Letter No. **A1/16437/2003**

Sub: CMDA - Planning permission - Construction  
of Ground Floor shops (commercial) building  
at Door No.23A, T.H. Road in S.No.162/60  
of Madivilagam Village, Chennai - Development  
charges and other charges to be remitted -  
Regarding.

PLAN SHOWING PROPOSED CONSTRUCTION OF SHOPS AT PLOT/DOOR NO:23 A, T.H. ROAD, SURVEY NO:162/60 OF MADAVILAGAM VILLAGE, THIRUMALISAI TOWN PANCHAYAT.

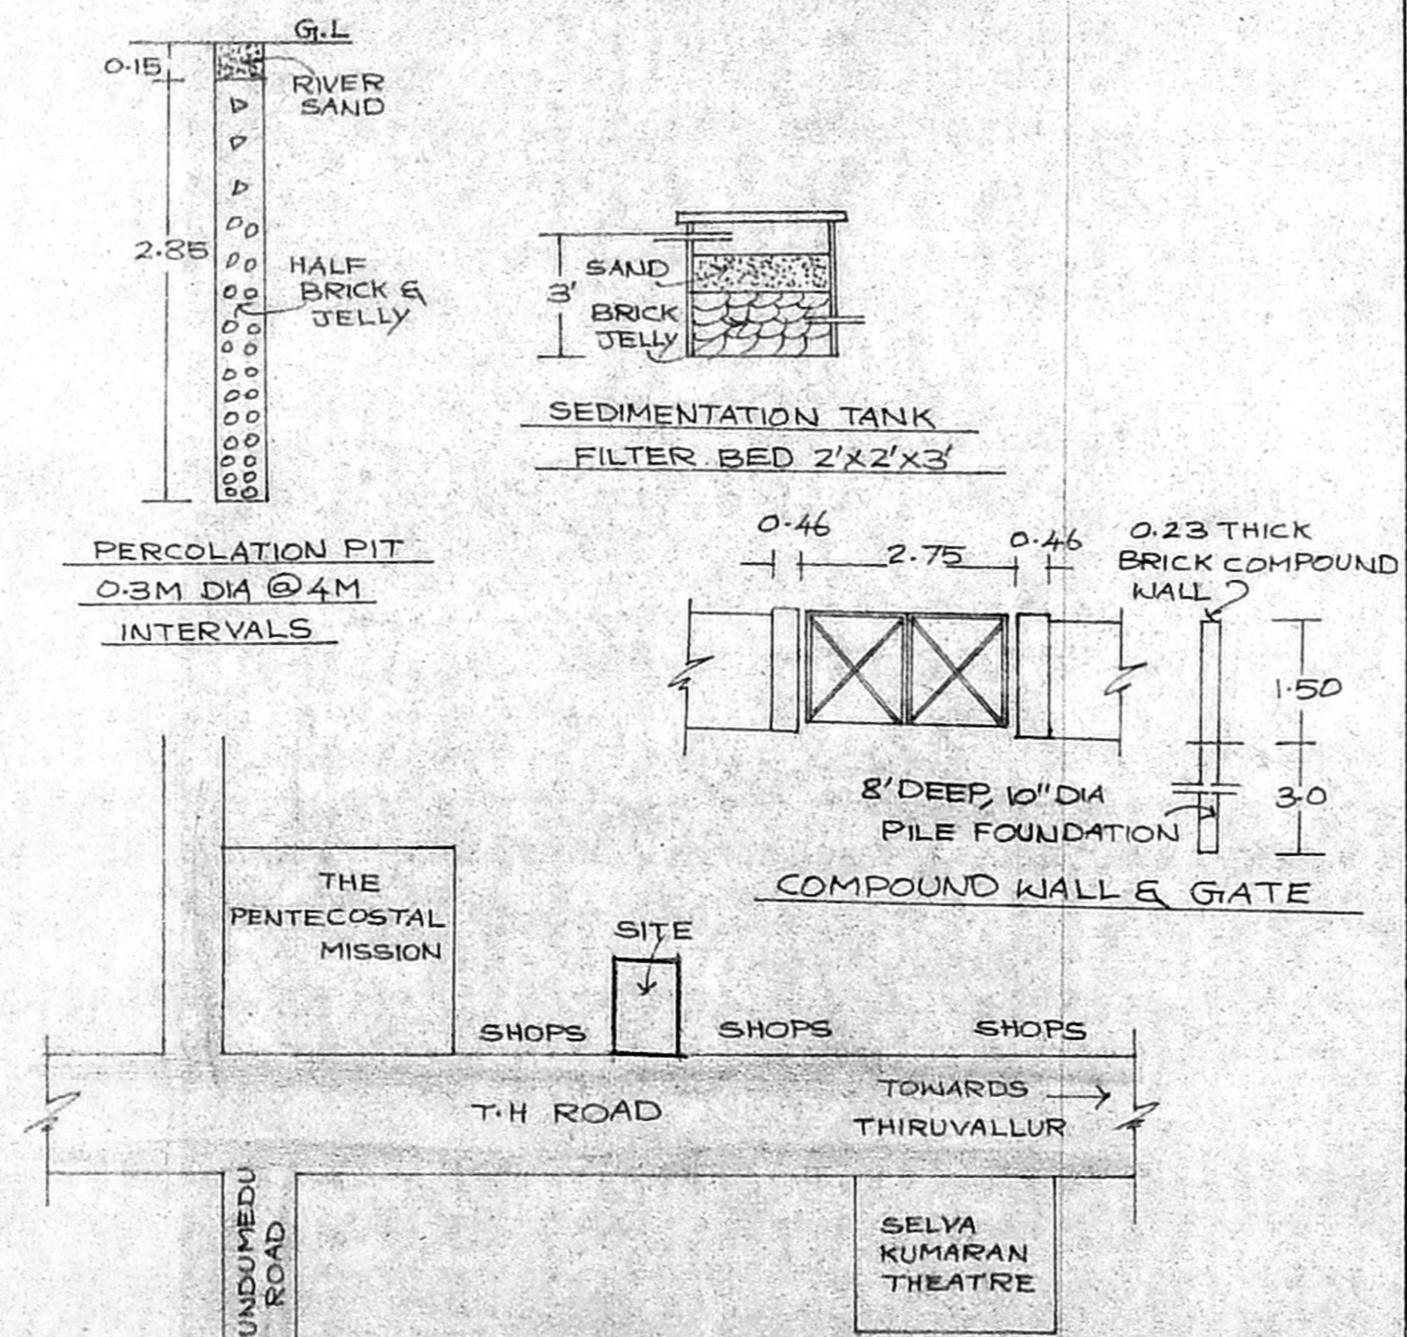
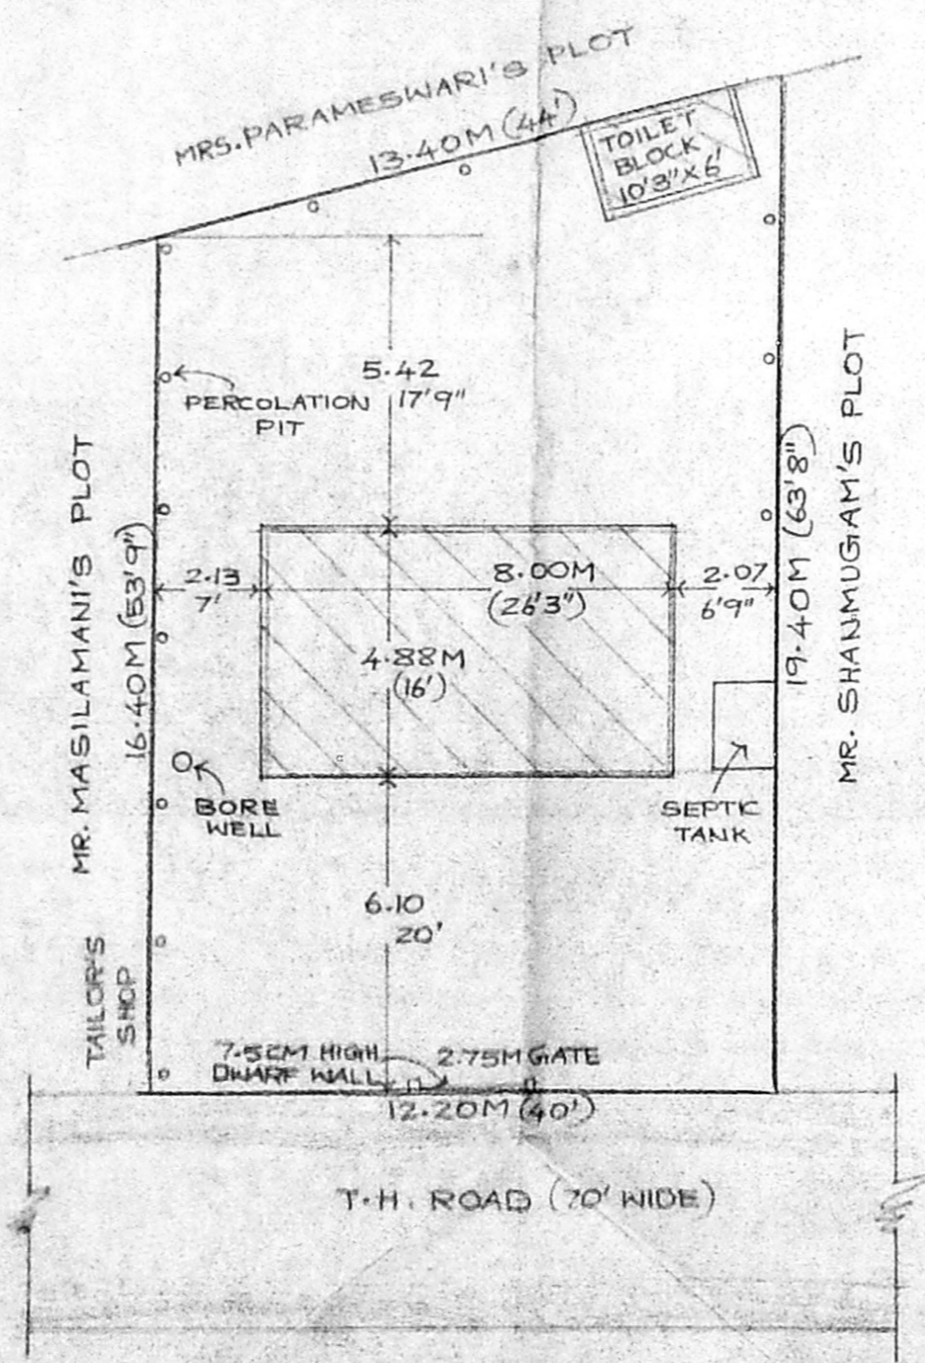
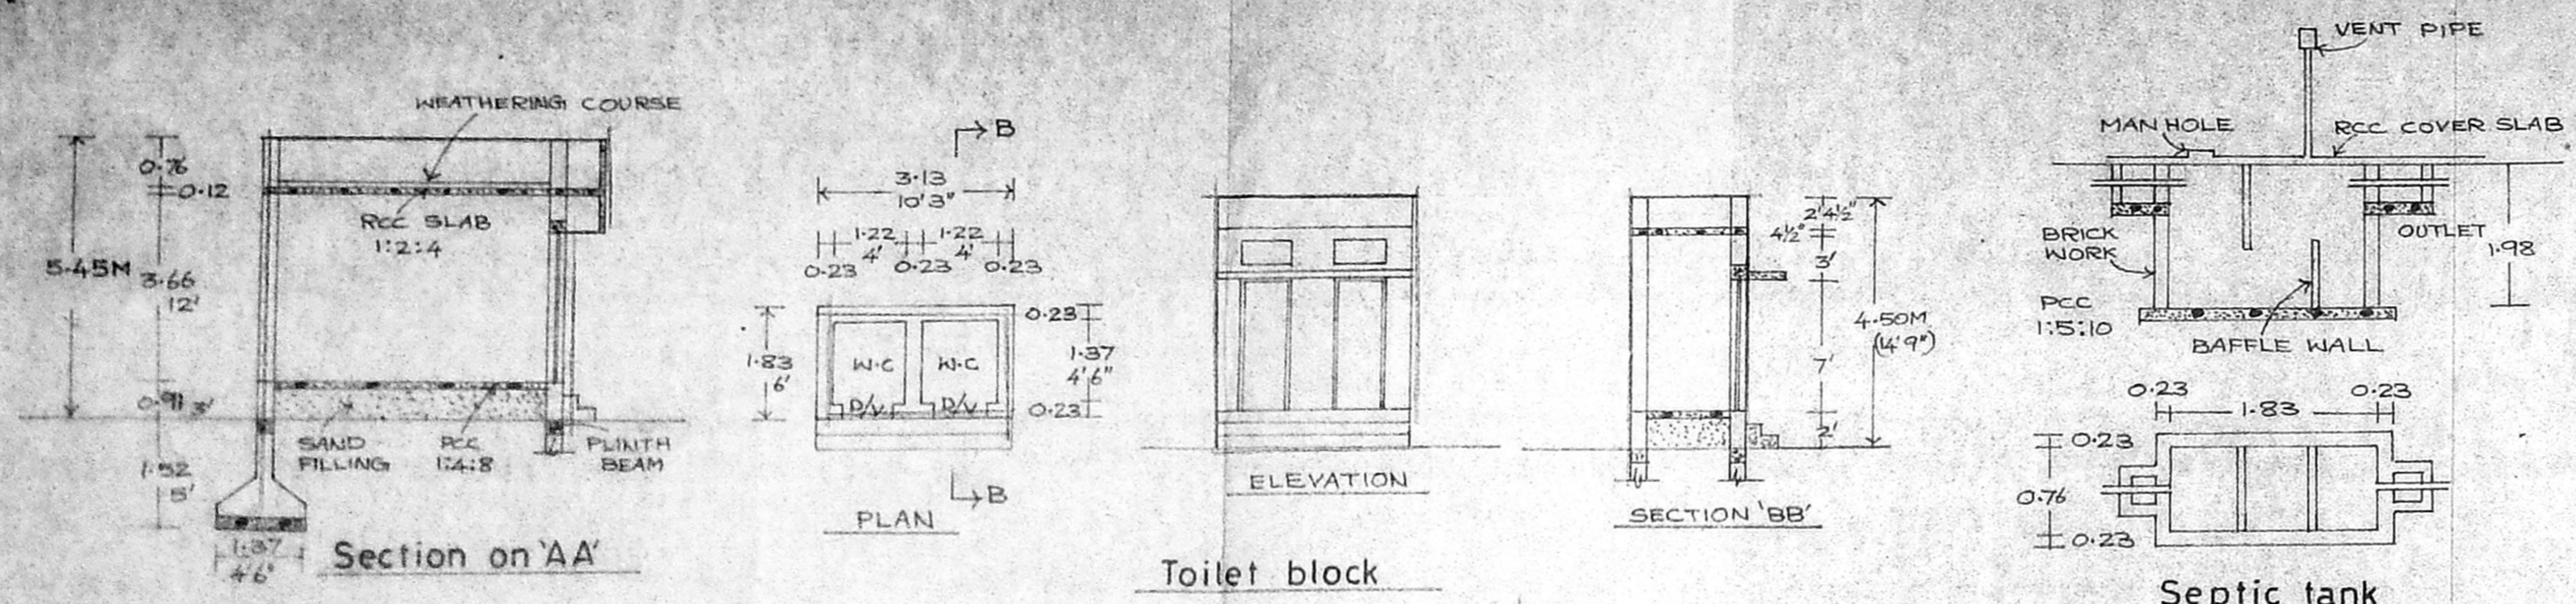
- a) Rain water conservation regulations stipulated by CMDA should be adhered to strictly.
- b) Basement height of 0.91mts to be provided.
- c) Compound wall details with section/elevation with gate position and 7.5cm dwarf wall along the gate to be provided.
- d) Rain Water Harvest pits to be shown on all arounds the plot.
